**Planning Application No 3/2026/0053**

**Location: Cow Ark Farm, Clitheroe Road, Whitewell, BB7 3DF**

**SUBJECT: Planning Application 3/2026/0053**

A South Elevation
1:100

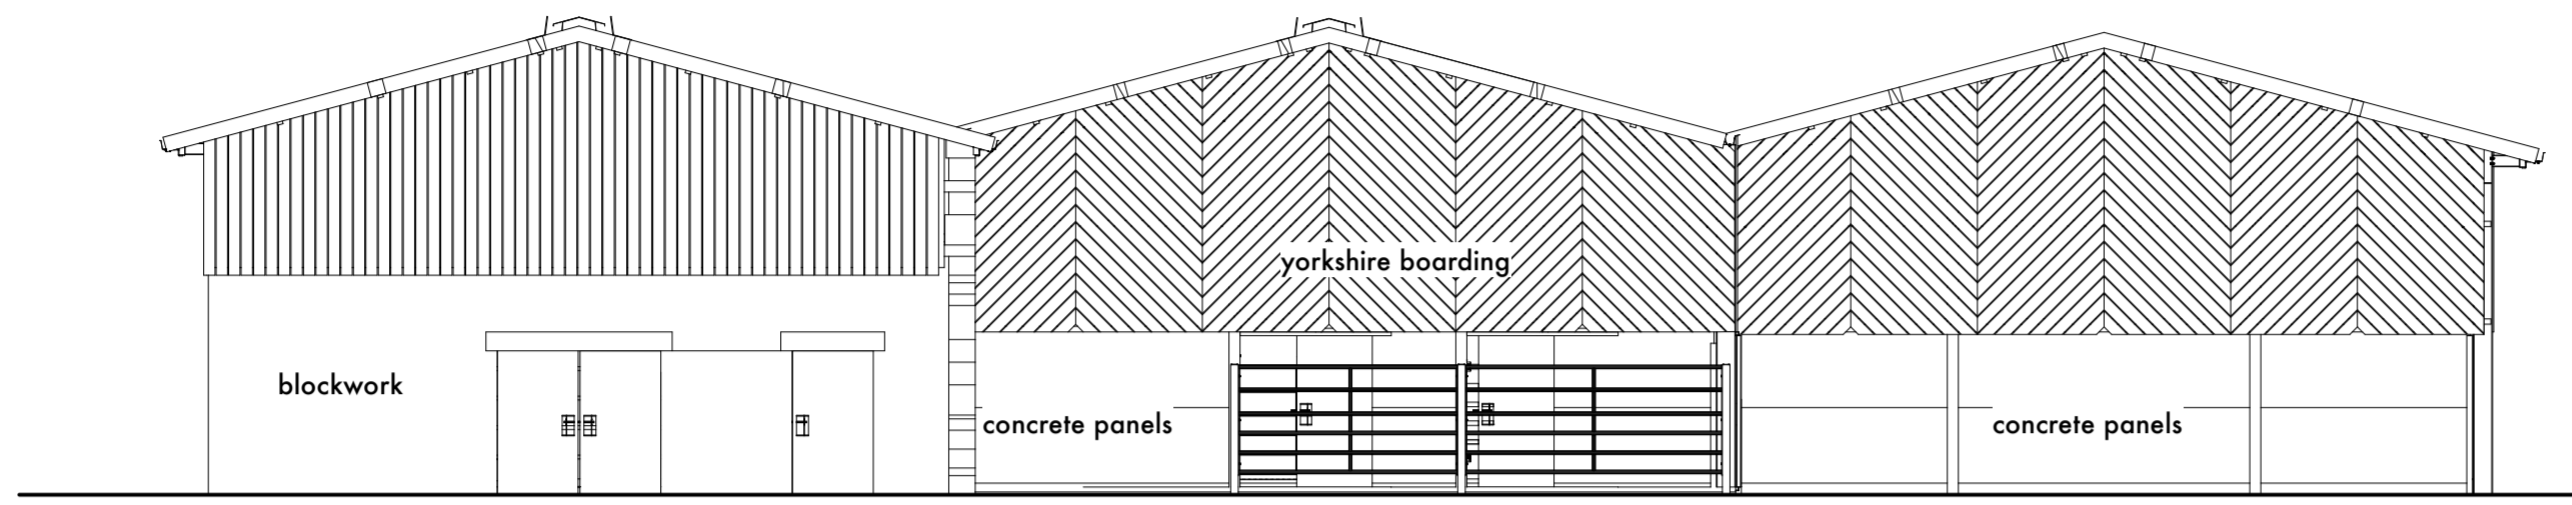
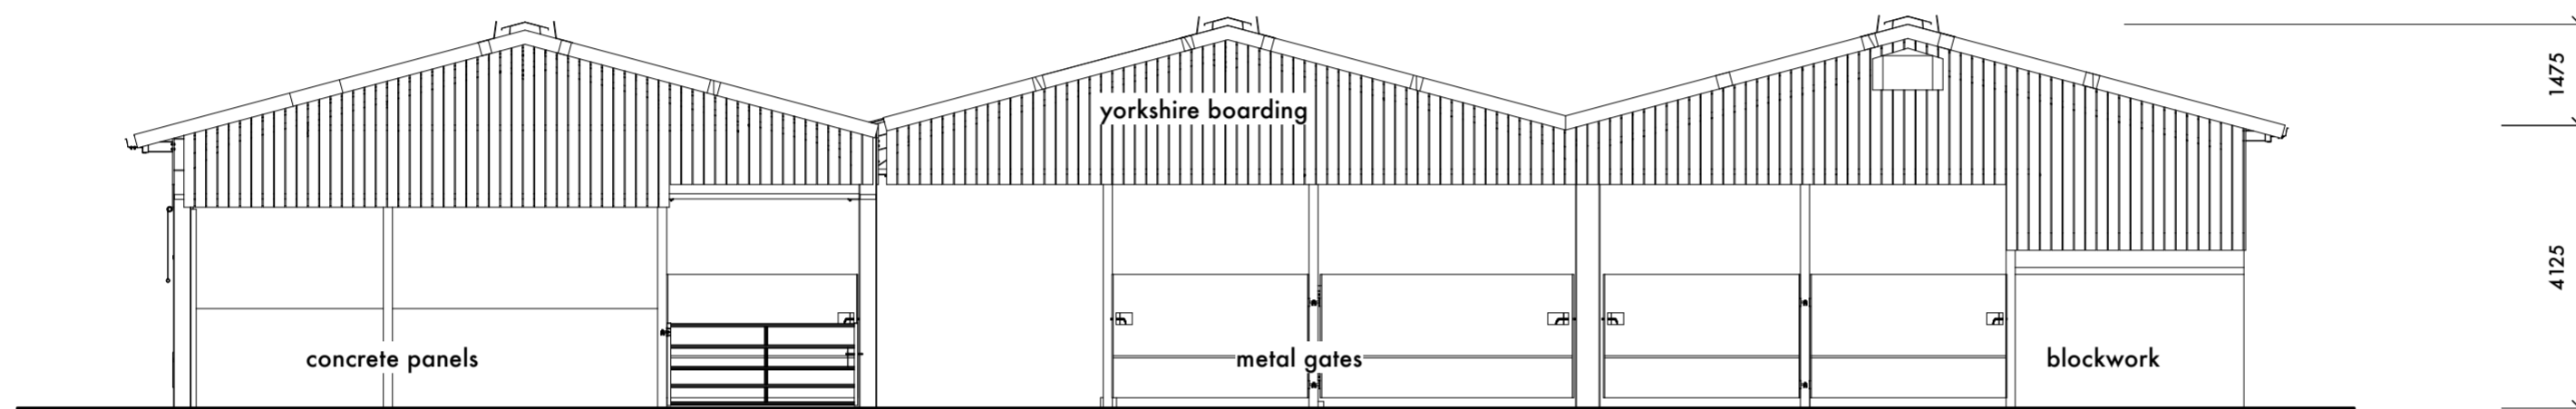
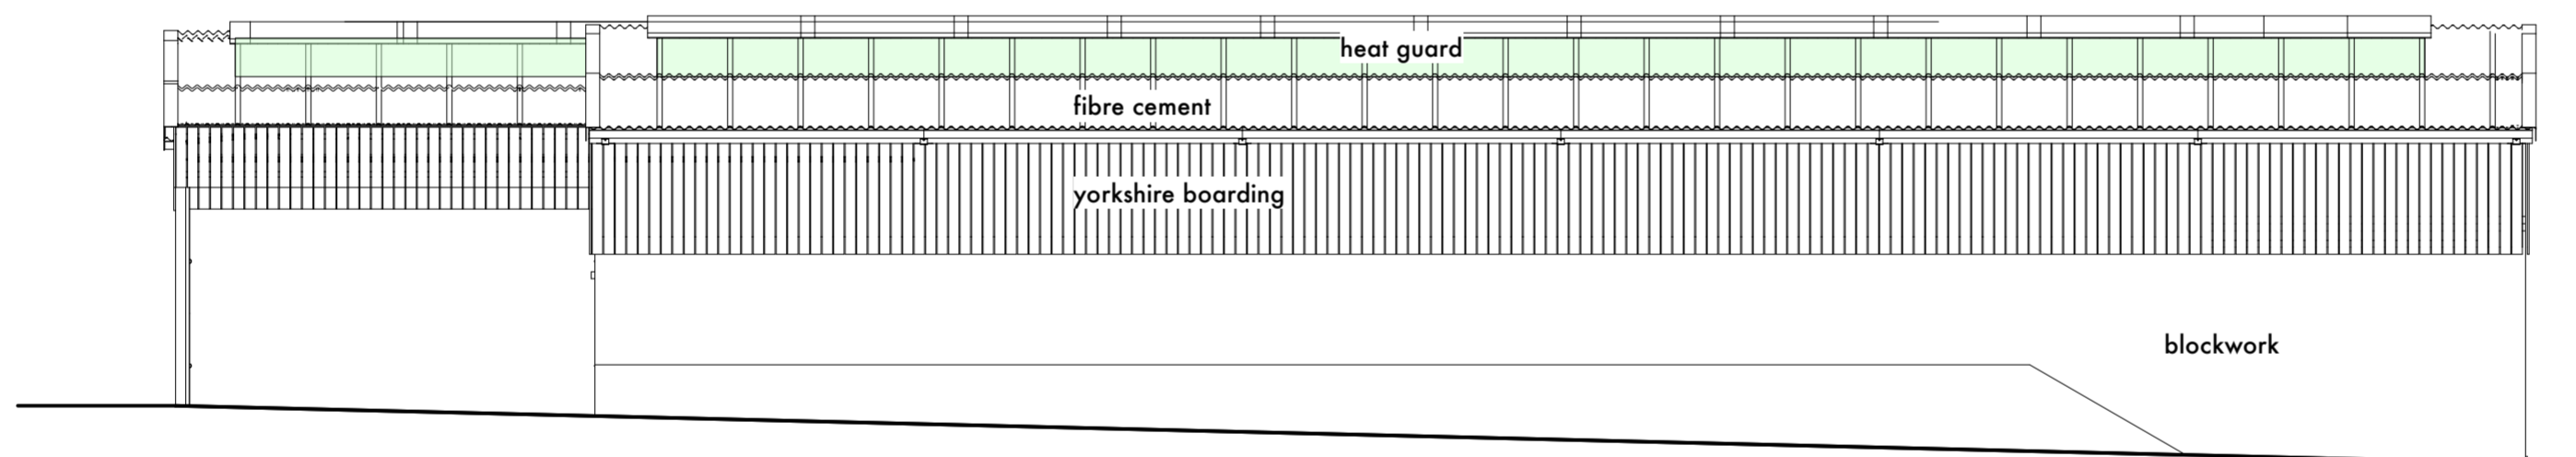
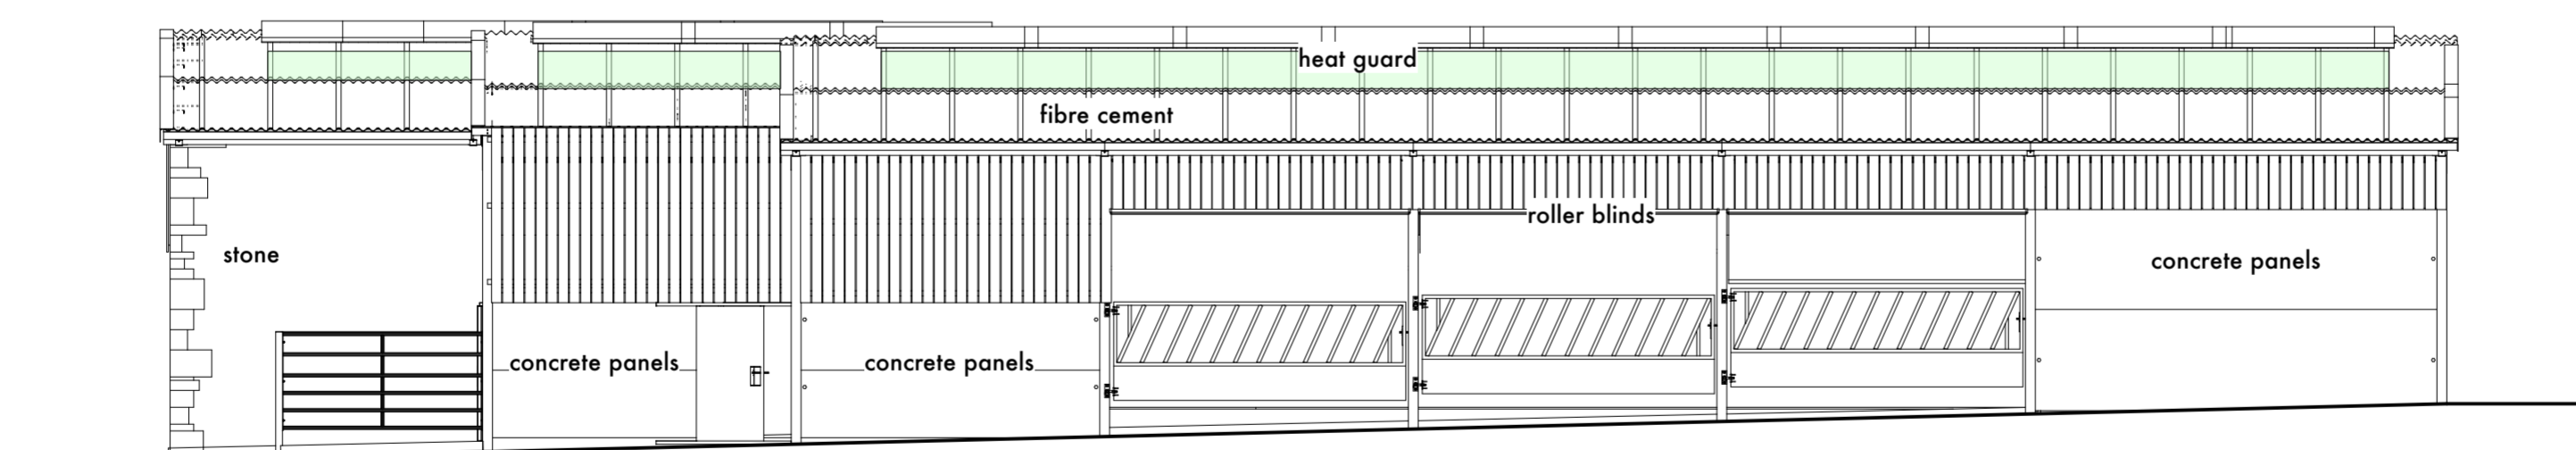
The new farm buildings now dominate the sky line of this small hamlet and are highly visible as you approach over Cow Ark bridge from Clitheroe, and from the adjacent properties. Photos attached (1 & 2) show the original Cow Ark Farm in 2005 and the new view as driving in to the hamlet. In our opinion in an AONB these changes are extreme.

We have read the supporting statement for the application which makes several valid points regarding the choice of materials for construction and roofing. We would however argue that even so these new buildings are out of character and overly dominant. The use of concrete blocks is in stark contrast to surrounding properties and as per the original permission granted in 2005 for the barn nearest to the road, should be stone clad on the lower sections. This was stipulated originally but has never been done and indeed the applicants have only recently part clad one small wall in stone 20 years after the original build. Is the intention to clad them all? Will this be enforced with a timescale this time around?

In our opinion the new farm buildings are of an intrusive and visually prominent form causing harm to the rural landscape and the setting of the listed buildings on either side on them. They completely change the nature of the area.

**B** Proposed Floor Plan  
1:100

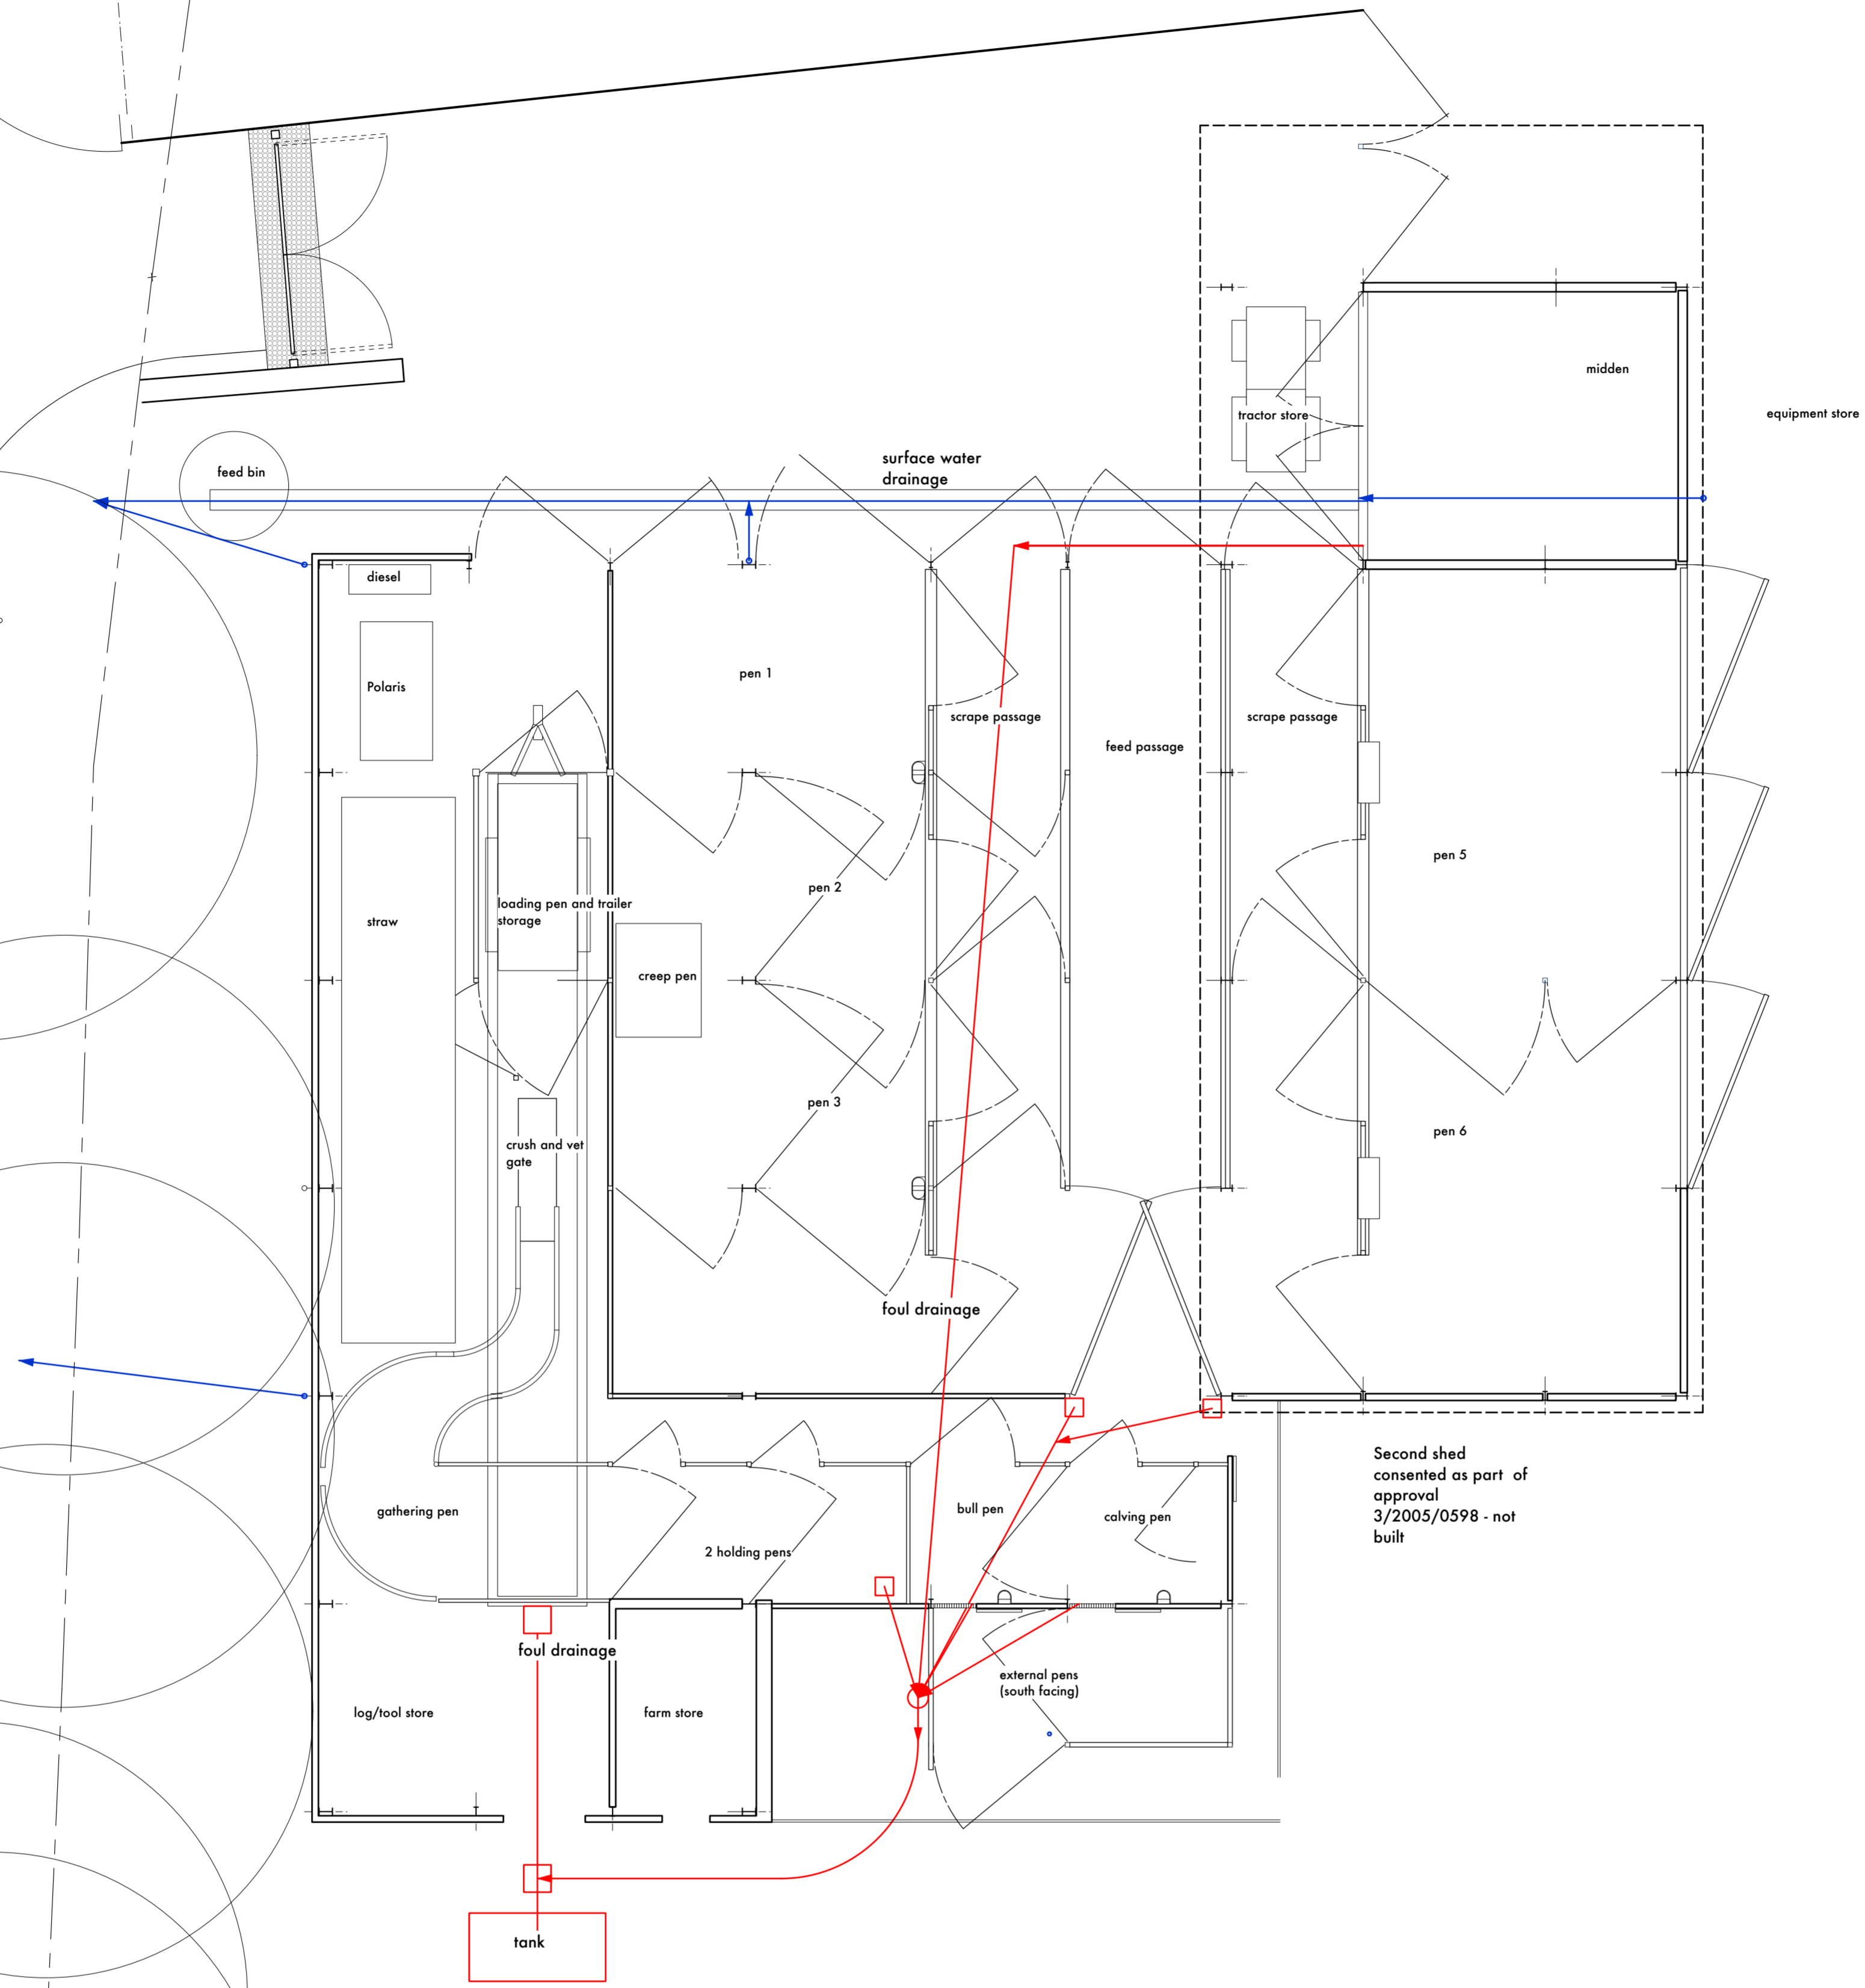
The new midden has increased from 40-60 sqm. FYM has always previously been stored off site. Presumably this will continue as the provision of the new midden is stated to be sufficient for 18 cows for 13 weeks. As the applicant justifies the size of the new buildings partly for an increase to 50 head of cattle – which will be indoors from roughly October to April (say 24-28 weeks) as stated elsewhere in the application. Hence the practice of storing off site will need to continue as

On a similar note the dirty water tanks could be deemed insufficient for the period of time the cows are indoors and for the stated increase in herd size. With cattle producing an average of 50 litres per day of dirty water (urine, minor wash down and rainfall on contaminated areas in open sided barns). Where will this all go and are all the necessary permits in place? We are concerned re potential overflow and discharge into Cow Ark Brook if the herd size increases.

We are also significantly concern by the lack of information regarding the dirty water storage. The tank as shown on the Drainage Strategy appears to be far to small to provide sufficient capacity for the proposed use. Although we do often recommend covering of FYM stores, we expect proper calculations and associated infrastructure to be included. The lack of information suggests this has not been done, and would pose a risk of leaks to the nearby water course – Cow Ark Brook. Cow Ark Brook is a designated Biological Heritage Site, and contains several species listed in Section 41 (S41) of the 2006 Natural Environment and Rural Communities (NERC) Act, including Eel, Salmon and Trout (Sea and Brown). These species would be severely negatively impacted by any dirty water emanating from this development. There will be other impacts on other species from this development, such as Bats, which are endangered.
